Your ref
Y/75/19/DOC

Our ref
PLAN-029635

Proposal: Approval of details reserved by condition imposed under ref Y/5/17/OUT relating to Condition Nos 11 - drainage strategy, 12 - protect existing public sewer, 13 - surface water drainage scheme, 15 - SuDs system and 30 - 10% energy supply from decentralised & renewable sources.
Site: Y/75/19/DOC: - Cinders Lane, Nursery and Works to The Rear Cinders Lane, Yapton BN18 0JJ.

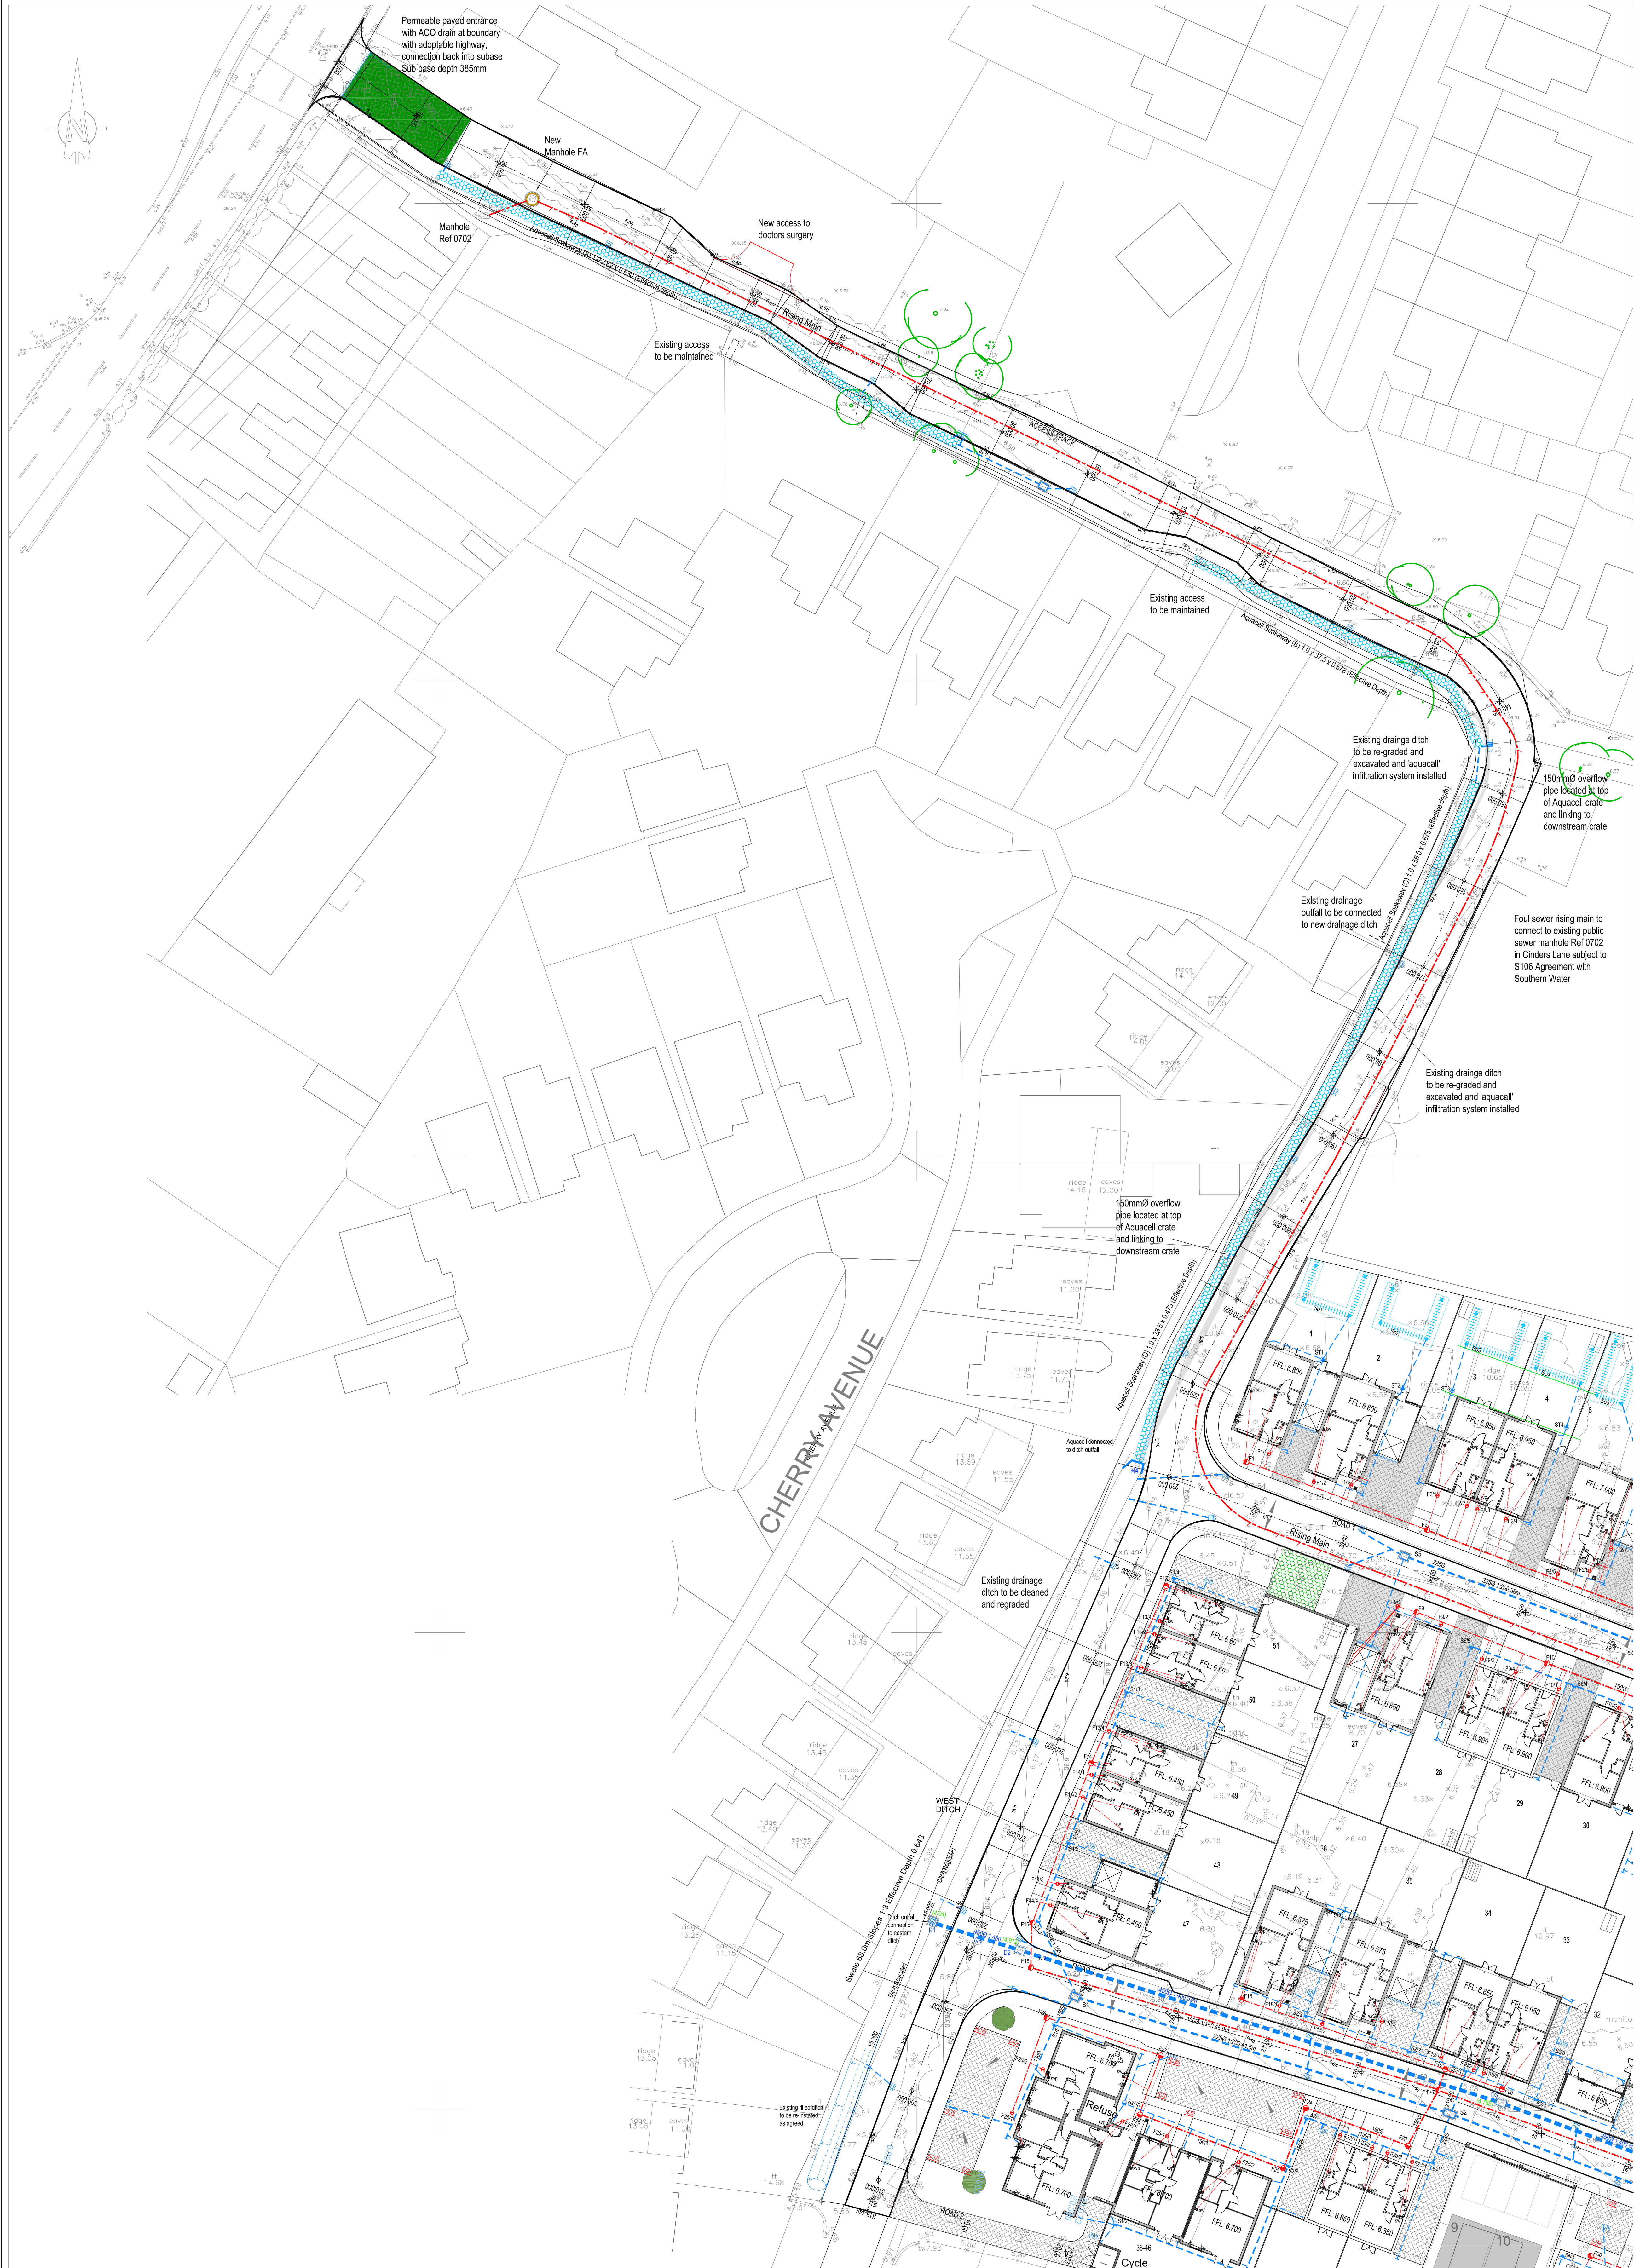
No details of sewer protection have been submitted by the applicant. We are therefore unable to recommend discharge of the condition 12
